From: Biazar, Shahab
Sent: Friday, February 12, 2016 12:19 PM
To: Yolanda Padilla Moyer; Chris Sholtis
Cc: Kevin G. Patton (kevin.patton@pultegroup.com); Abiel X. Carrillo (acarrillo@cabq.gov); Harmon Rita T. (rharmon@cabq.gov)
Subject: DPM FOR DEL WEBB PHASE 2 @ MIREHAVEN, TRACT M WATERSHED SUBDIVISION (H09D017F)

Based on your submittal for DMP for DEL WEBB Phase 2 @ Mirehaven (H09dD017F) received February 5, 2016 with engineering stamp date of February 4, 2016 the plans can be approved for Preliminary Plat. The following items must be addressed prior to grading permit and work order approval:

EXISTING BASINS MAP

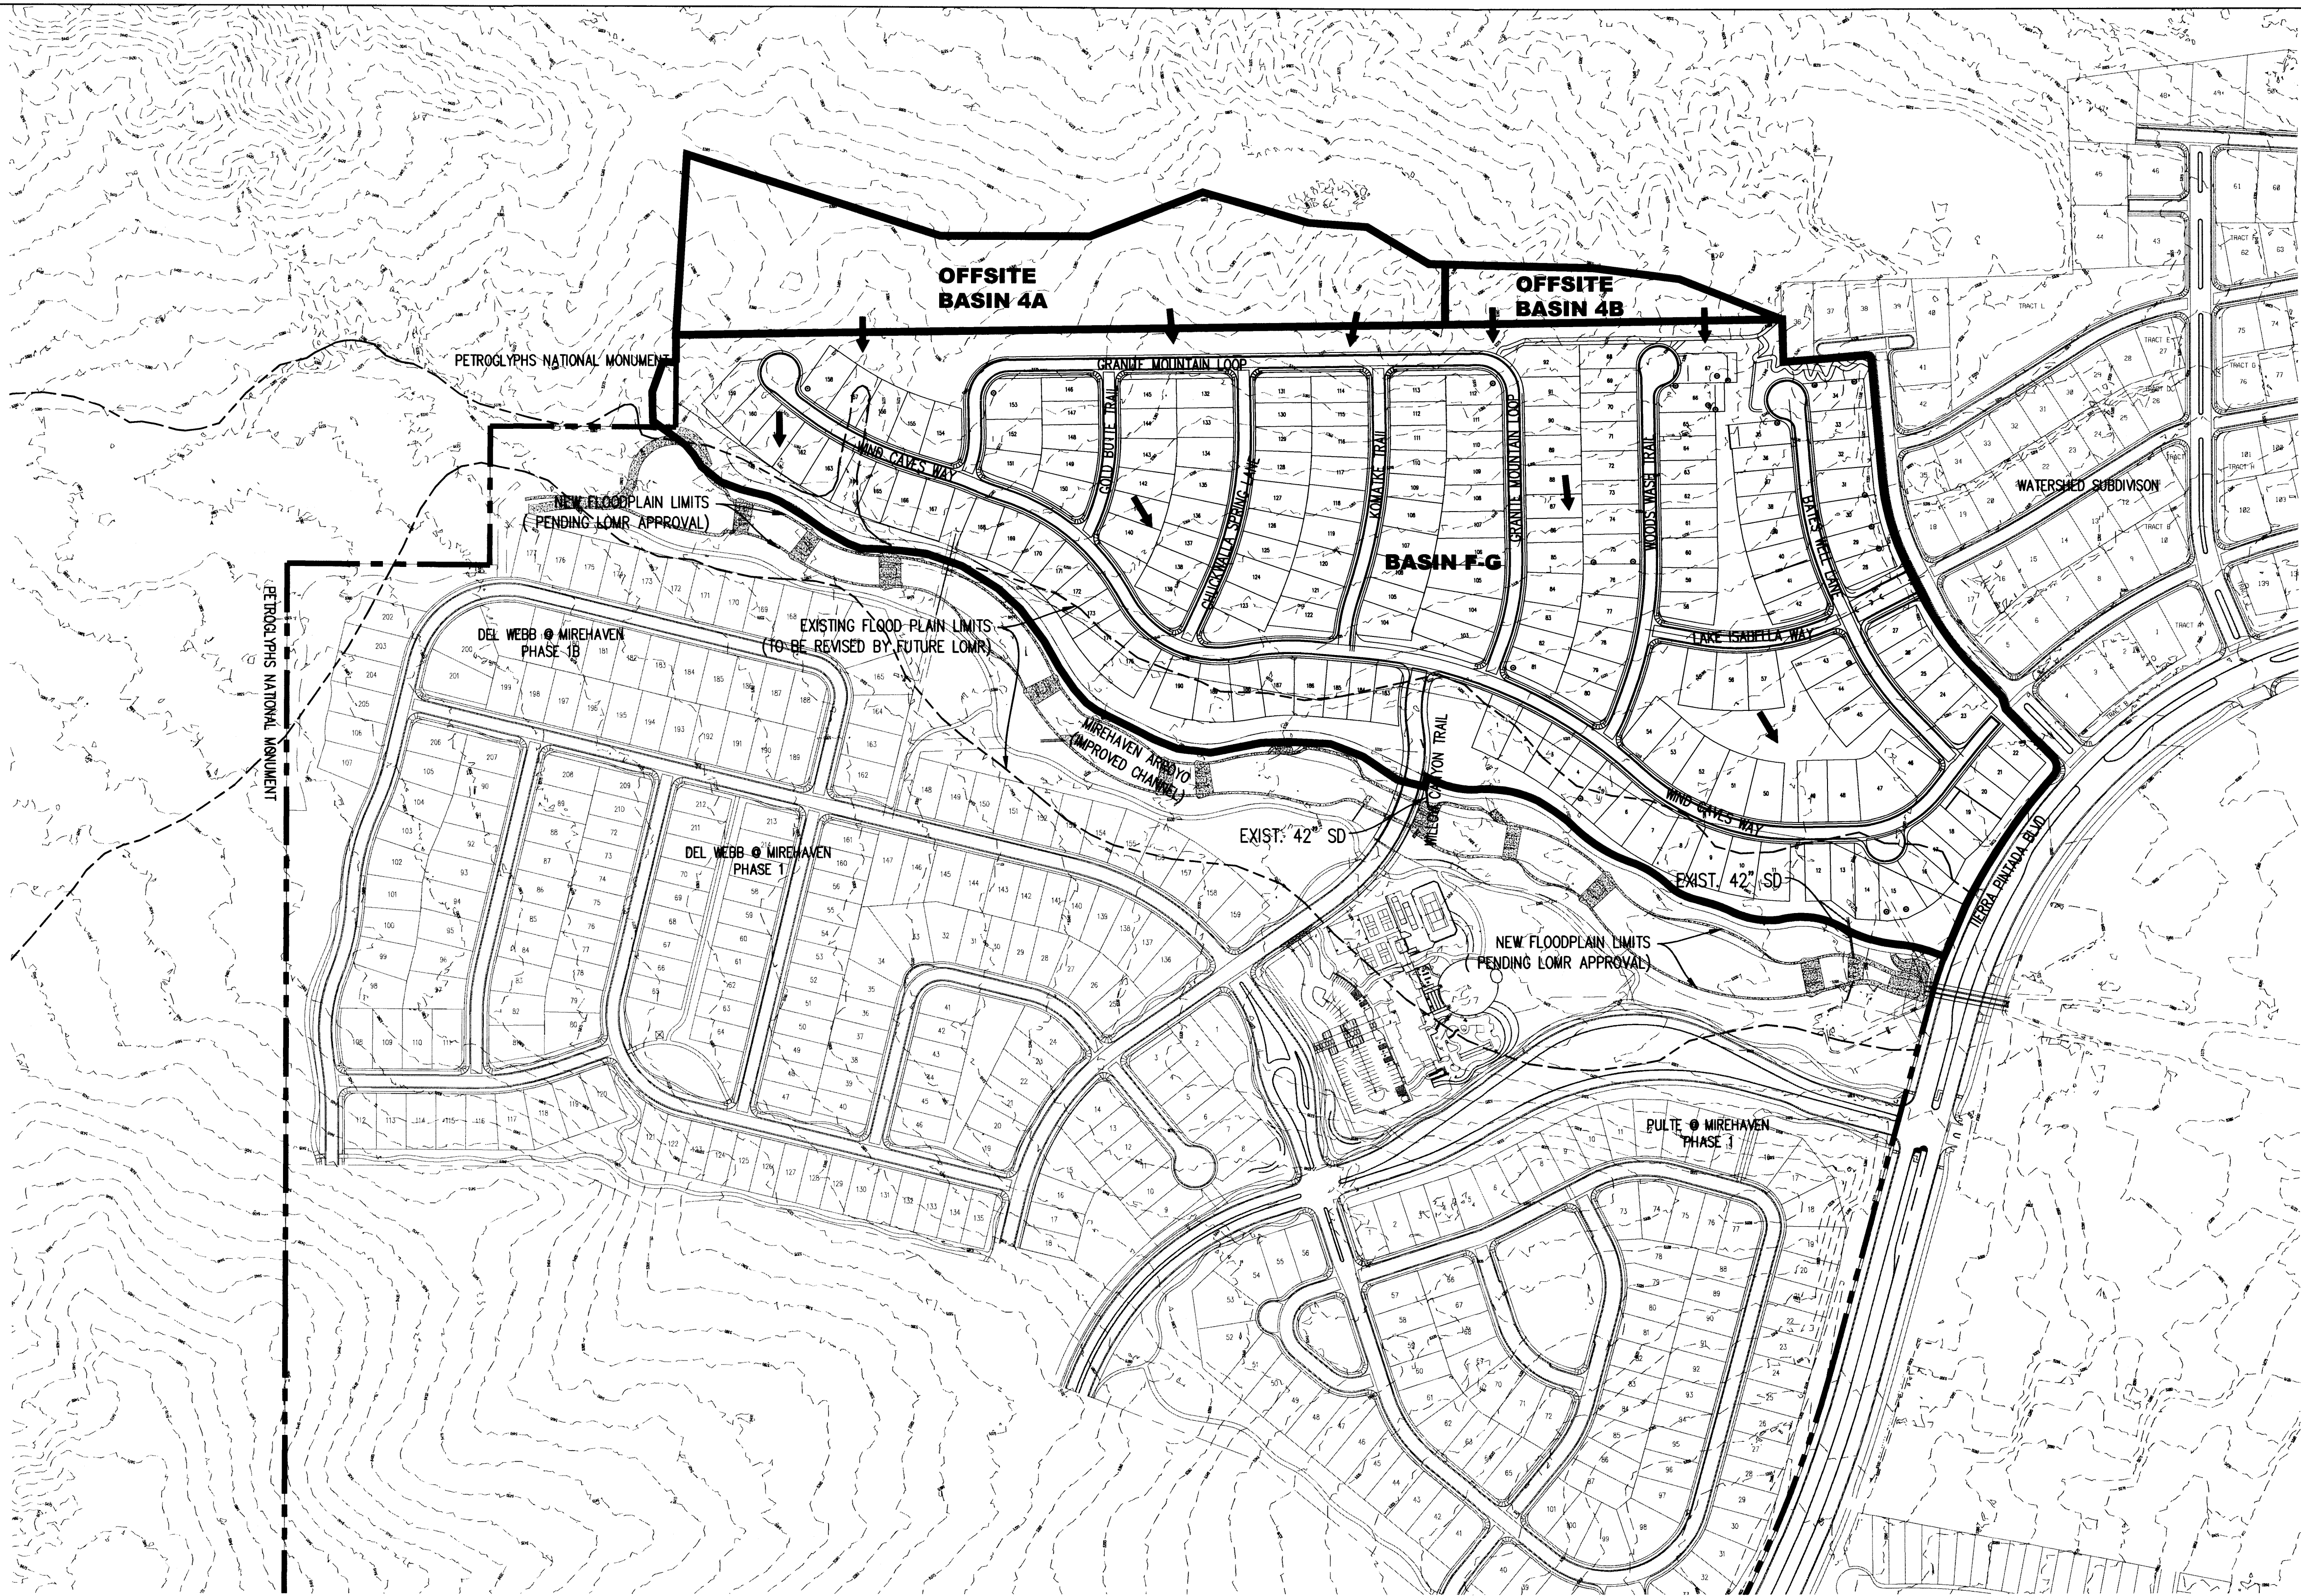
- Existing grades/topography should be provided at the east side of the project.

DEL WEBB @ MIREHAVEN PHASE 2
PROPOSED BASINS MAP

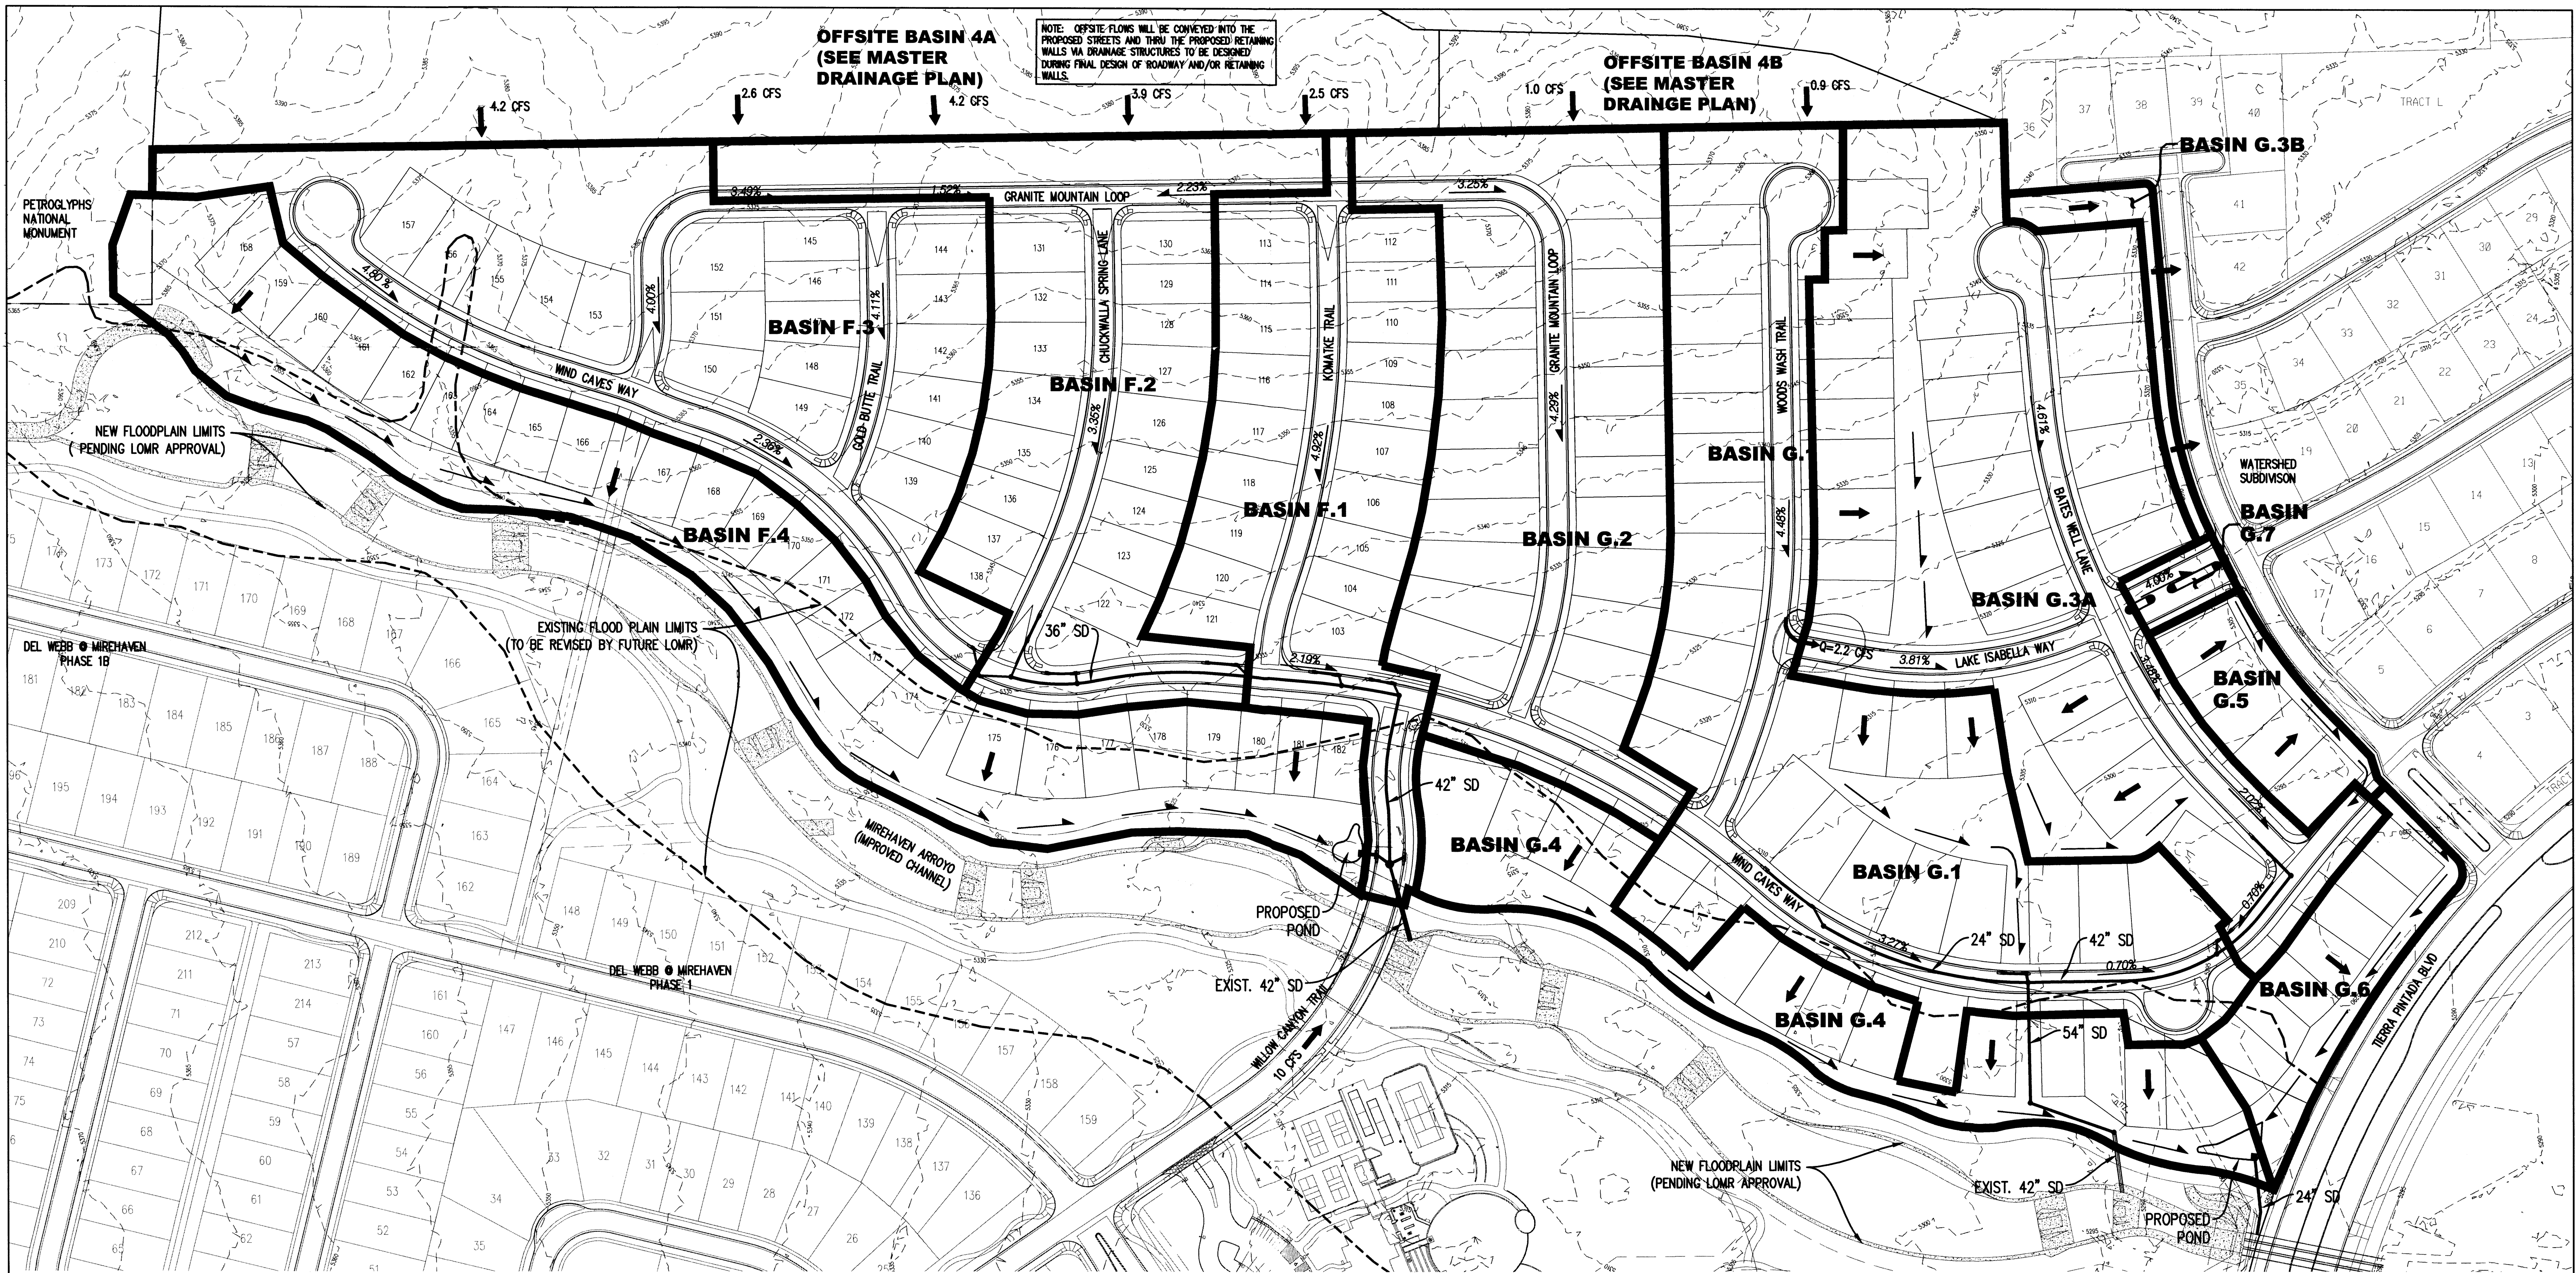
- Inlets 1 and 2 are called out on first section of the Wind Caves Way street hydraulics analysis sheet. It should be changed to Inlets 3 and 4.
- Double check the calculations for swales within Basins F.3 and G.4. Is right slopes on one of the swales is at 3%? In some areas the bottom of the slopes exceeds 8%.
- Small portion of the G.3 to the north does drain to West Creek Pl.
- Sidewalk culvert locations and calculations should be provided.
- Existing grades/topography should be provided at the end of project.
- First flush volumes are not shown for ponds within Basins F.4 and G.4.
